**Reference No:** 2017/62/93430/W

**Site Address:** 11, Foster Avenue, Crosland Moor, Huddersfield, HD4 5LN

**Description:** Erection of single storey rear extension and detached double garage

## Officer Report

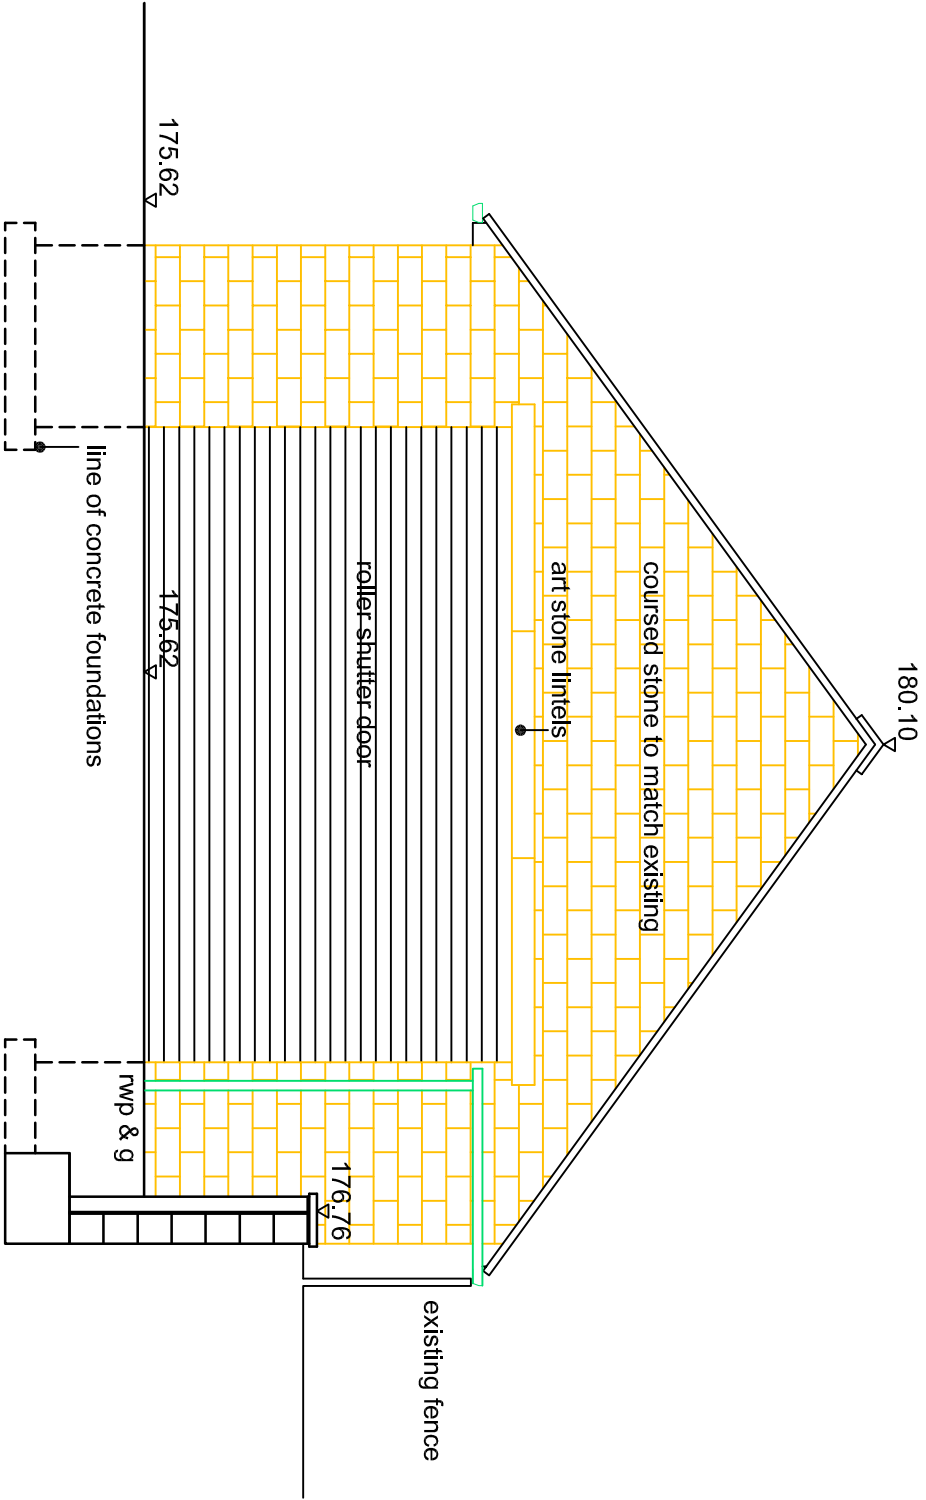
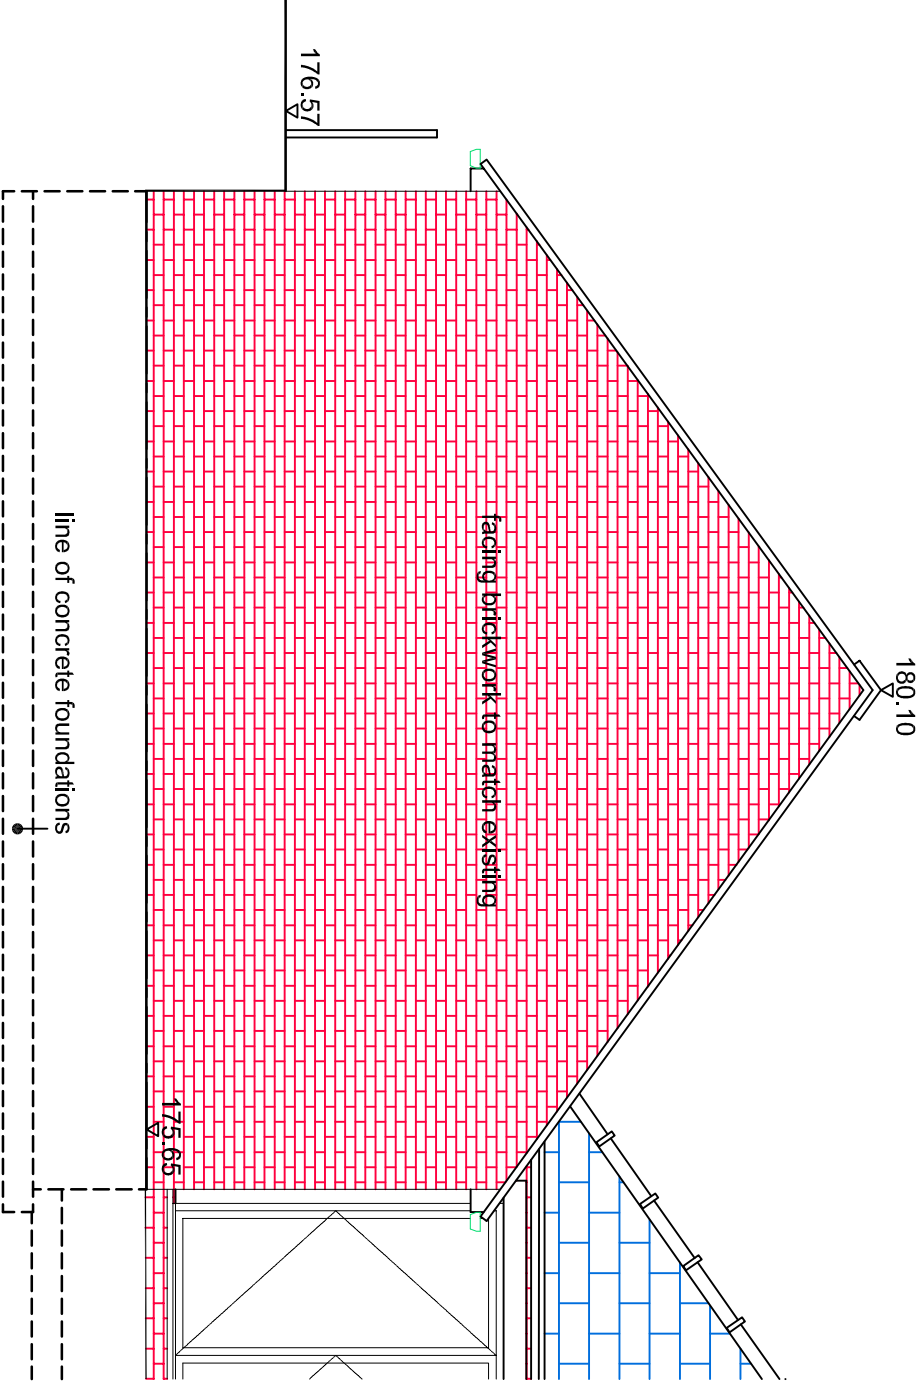
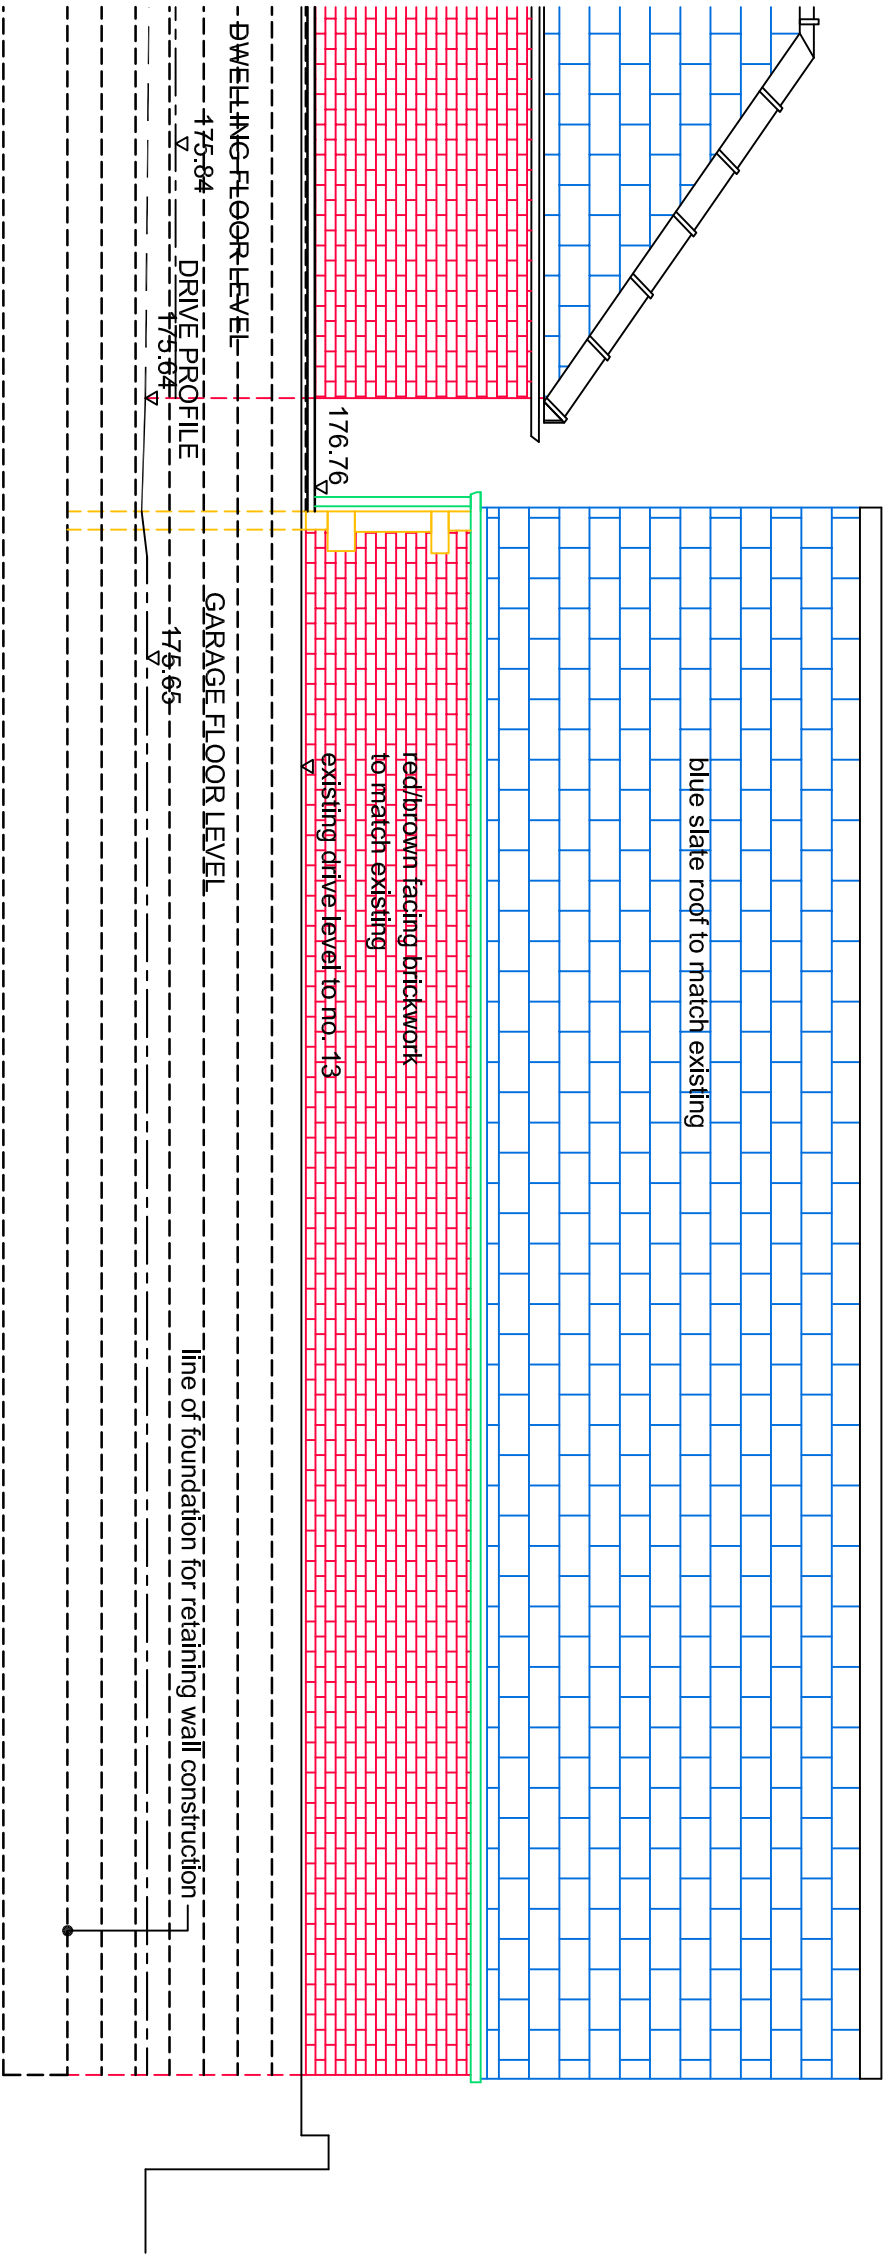
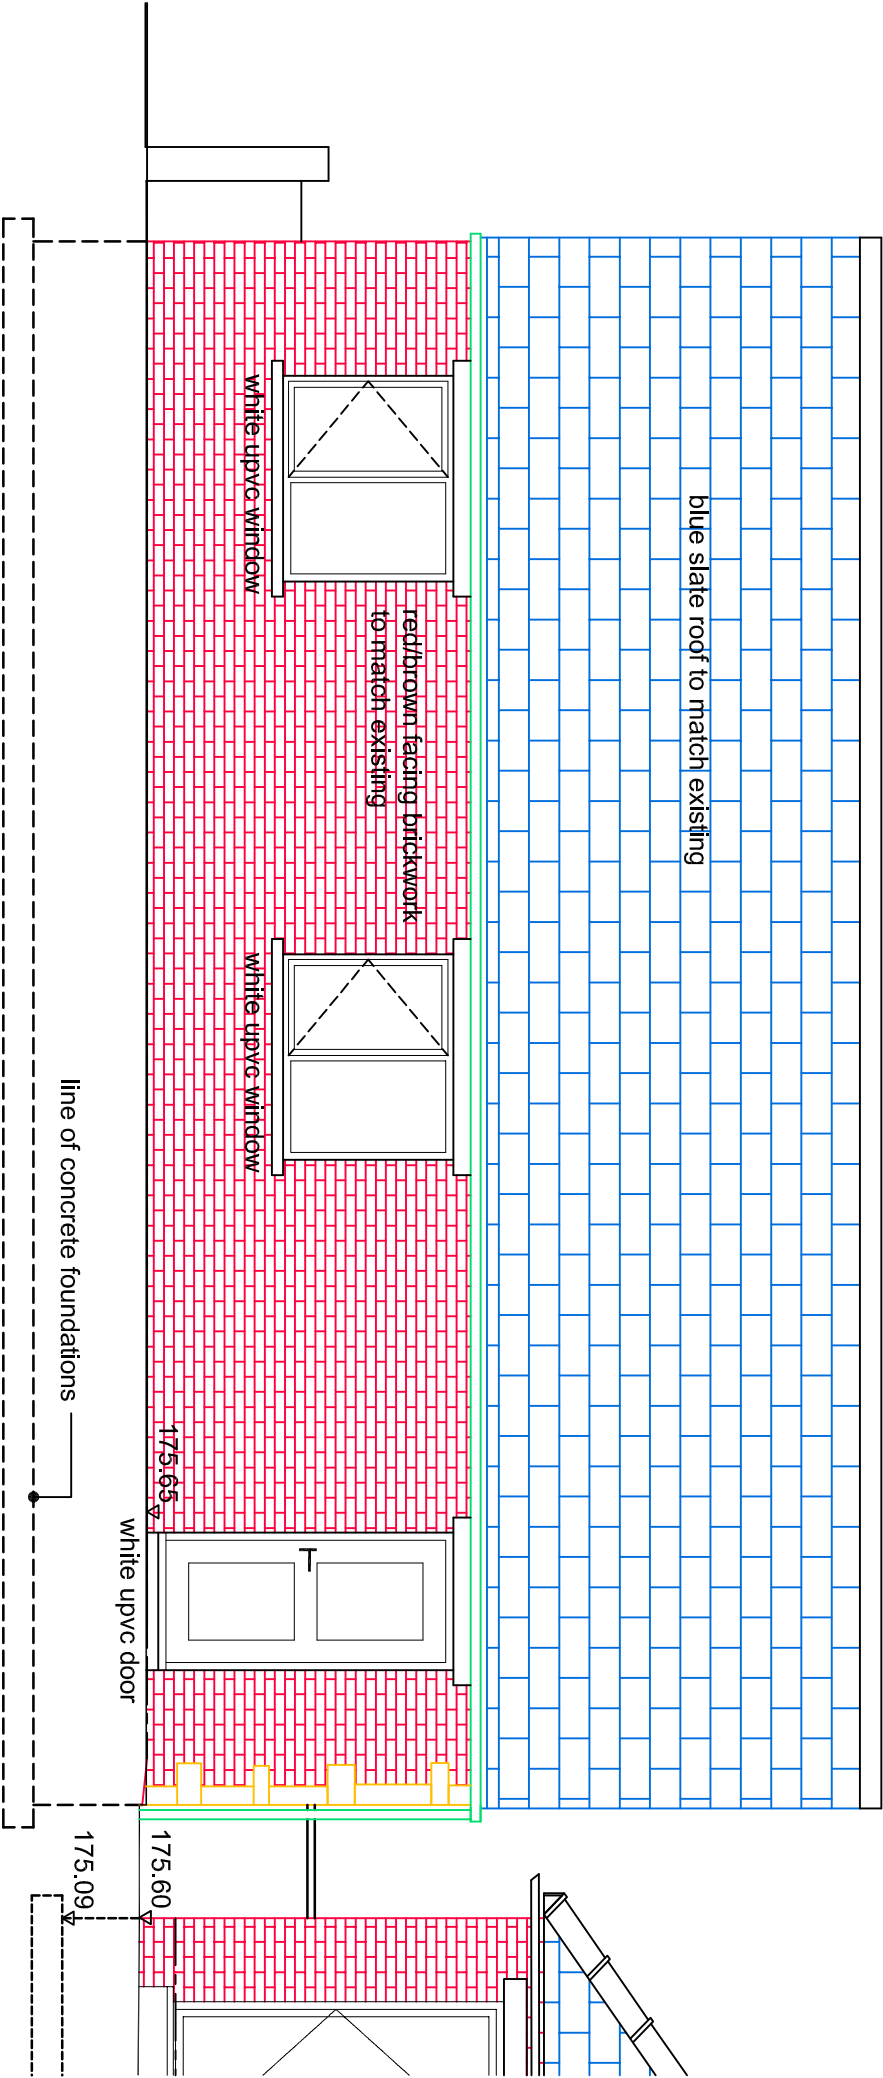
Although large in scale, the detached double garage will be viewed from the street scene although it will be set at a lower level than the highway therefore would not be viewed as a visually intrusive feature in the local area. The detached double garage roof height will also be set at lower height than the detached garage of the adjacent site no.13 Foster Avenue and would not exceed the ridge height of the host dwelling.

3. The external walls and roofing materials of the extension and detached garage hereby approved shall in all respects match those used in the construction of the existing building.
